<b>Consultation Response from KC, Conservation and Design</b>		
<b>2020/91919 The Co Operative Food, 19, Northgate, Almondbury, Huddersfield, HD5 8RX</b>		
<b>Demolition of existing supermarket and erection of block of 6 flats with associated parking (within a Conservation Area)</b>		
<b>Date Responded: 21.8.20</b>	<b>Responding Officer: Sue Oakley</b>	<b>Responding Ref:</b>
<p>The Co-Op food store at 19 Northgate in Almondbury is a modern single storey flat roofed building located within the Almondbury Conservation Area. Opposite this building is a row of terraced houses, one of which is Grade II listed (14 Northgate), and nearby to the south is the Grade II listed 43-51 Northgate, part of the former Rose and Crown public house. The site is located on the main thoroughfare through Almondbury and within the historic core of the settlement. This street is characterised by terraced residential properties and retail premises, and many of these buildings either face directly onto Northgate or have small front yards and gardens acting as a buffer. Historically, there was a short terrace on the proposal site which faced directly onto the road, typical of many buildings within the immedia

PROPOSED PLANS

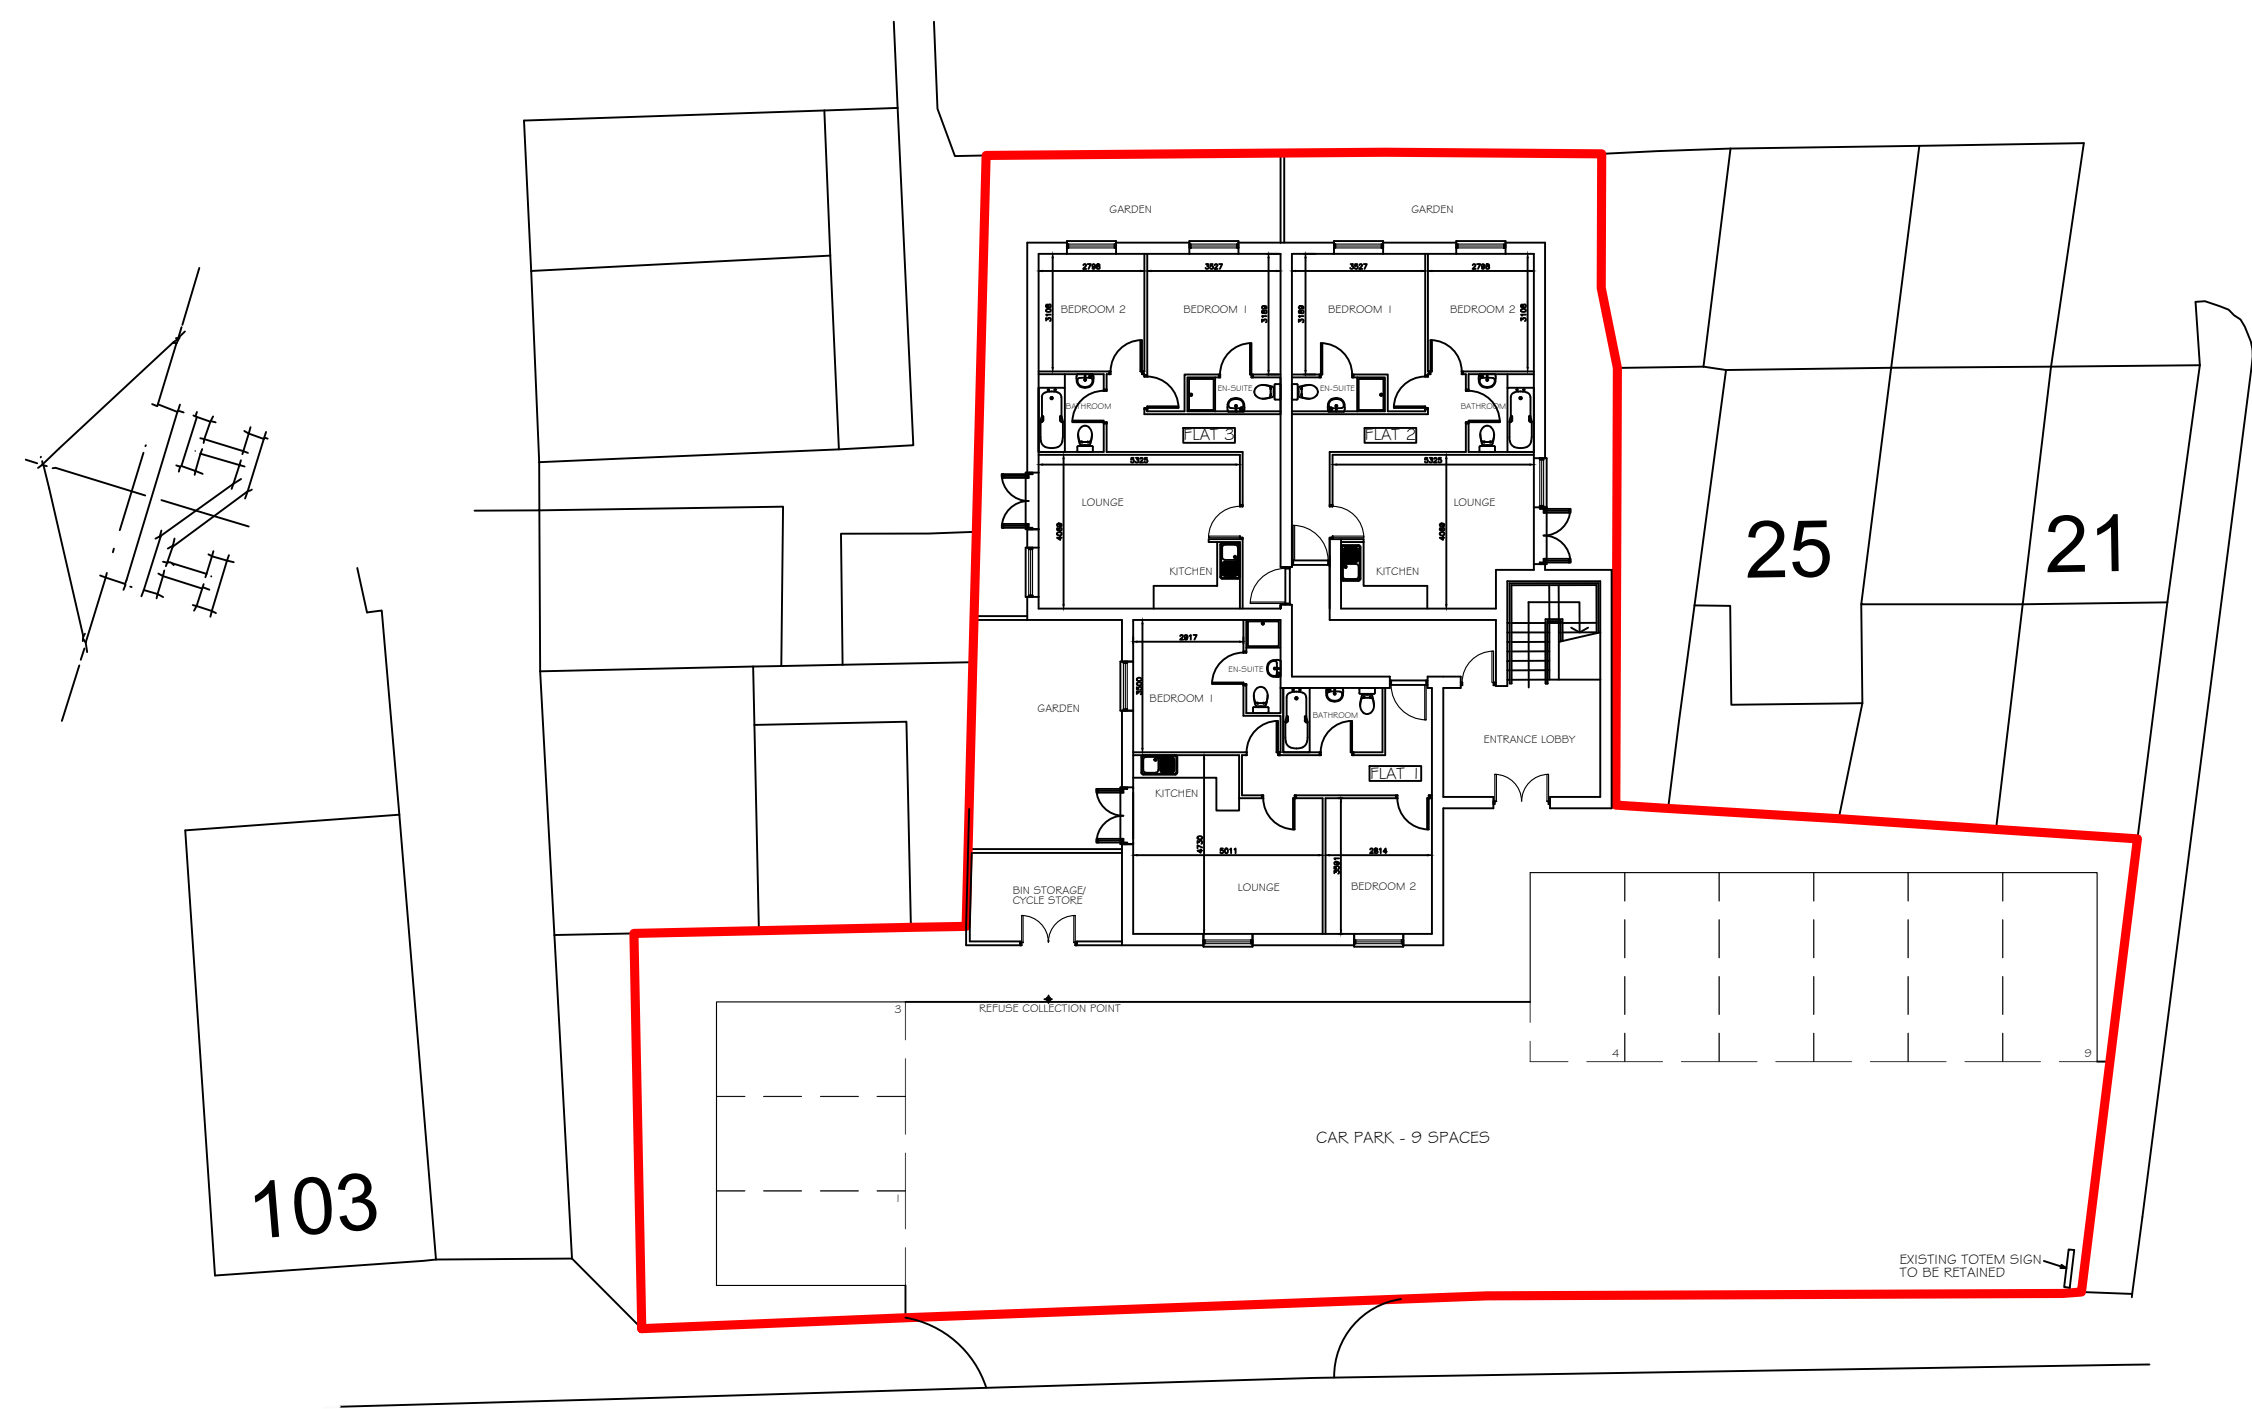
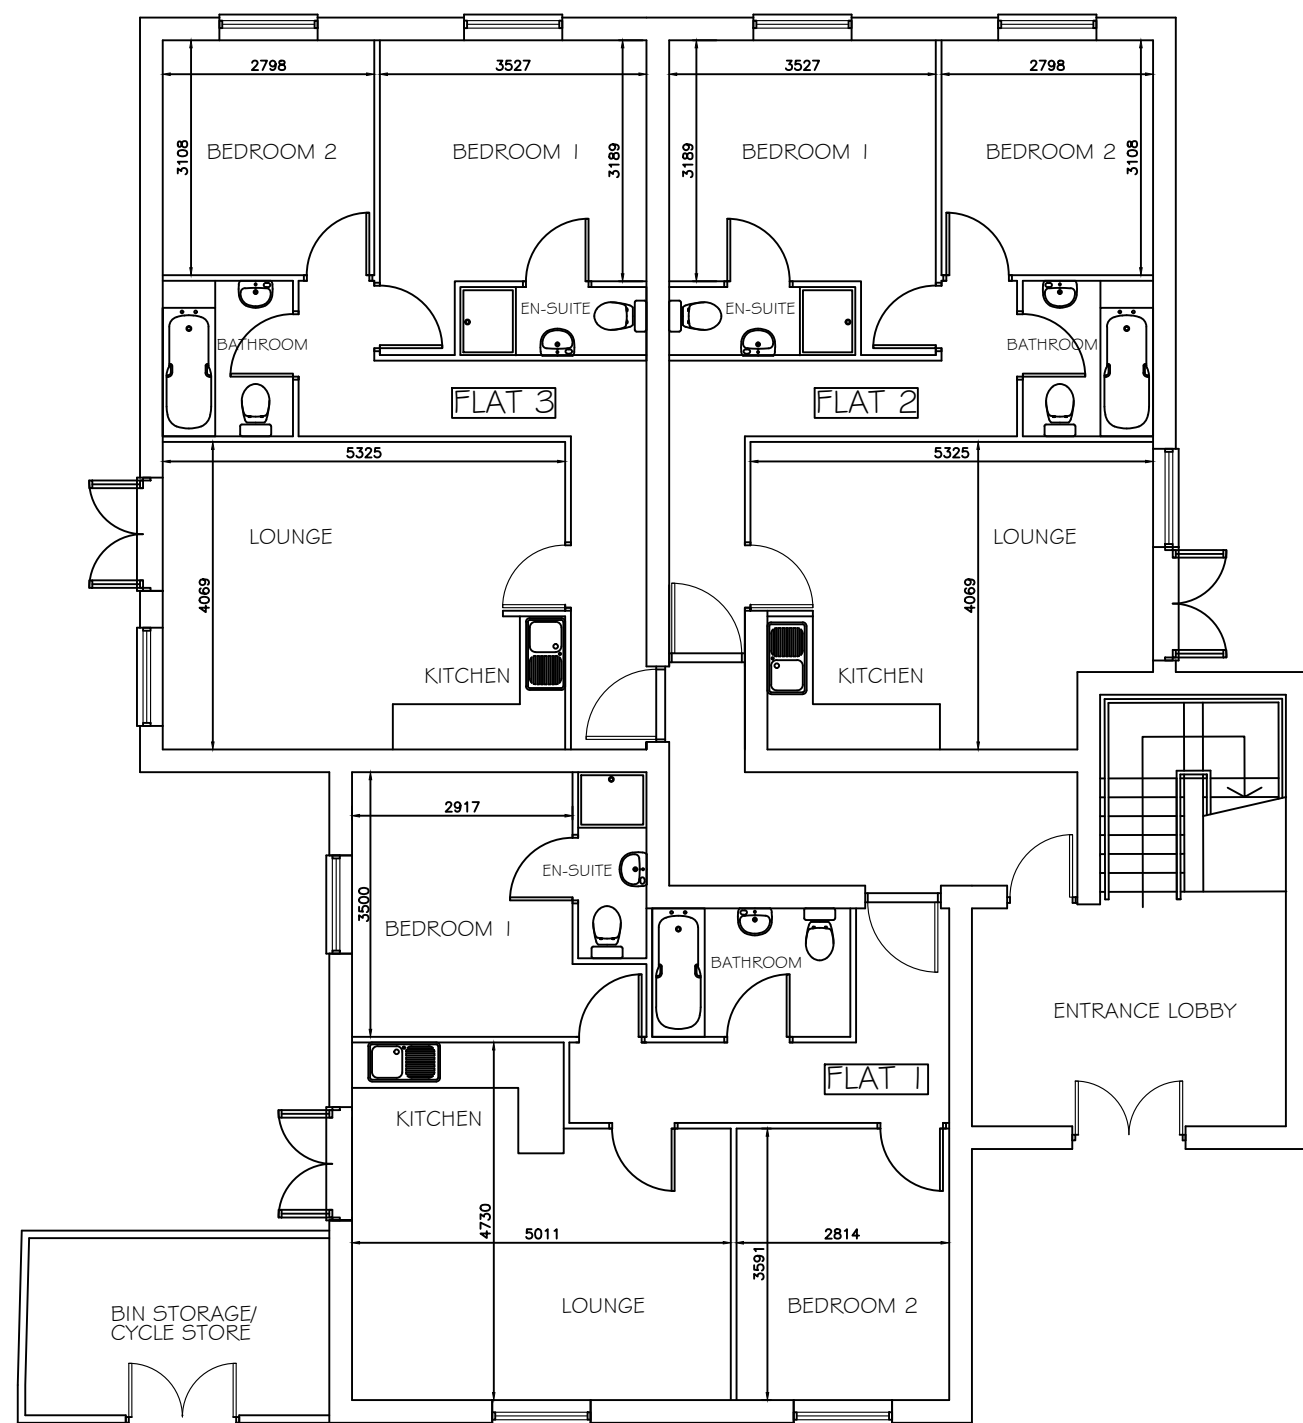
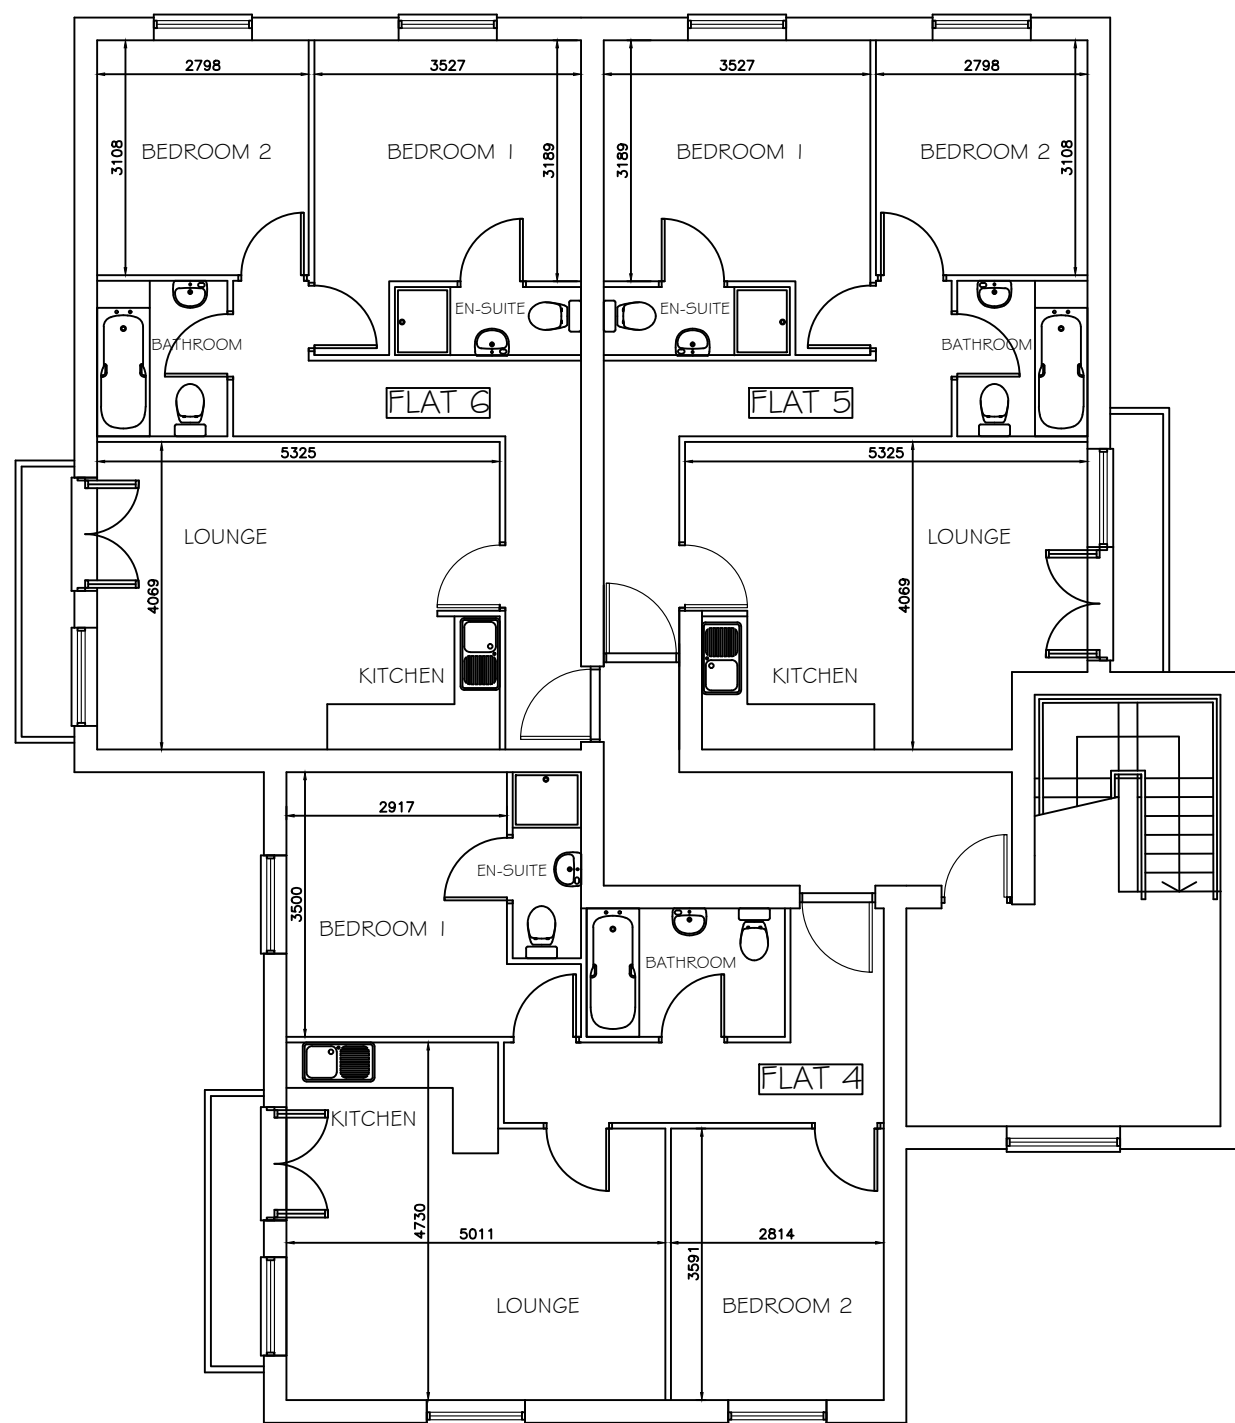
The heritage statement notes that the proposal will not cause substantial harm to the heritage assets and I would agree with this. However, it also states that the proposed scheme will have no impact on the conservation area or nearby listed buildings and will fit seamlessly within the conservation area. Although it is an improvement on the existing, I consider the design and layout to cause less than substantial harm to the character of the conservation area by the use of render, the design of the visible elevations, possibly the roofline (subject to clarification), and the expanse of tarmac on the front boundary which does not create an attractive street scene.

This is a good opportunity to enhance a prominent site within the conservation area and there are clearly public benefits in providing housing and improving this site, and I support a residential scheme in principle. However, I would prefer the design of the building to be amended to reflect the local character and the layout of the site to be re-designed to reflect the surrounding street scene and character, perhaps with the building brought forward on the site.
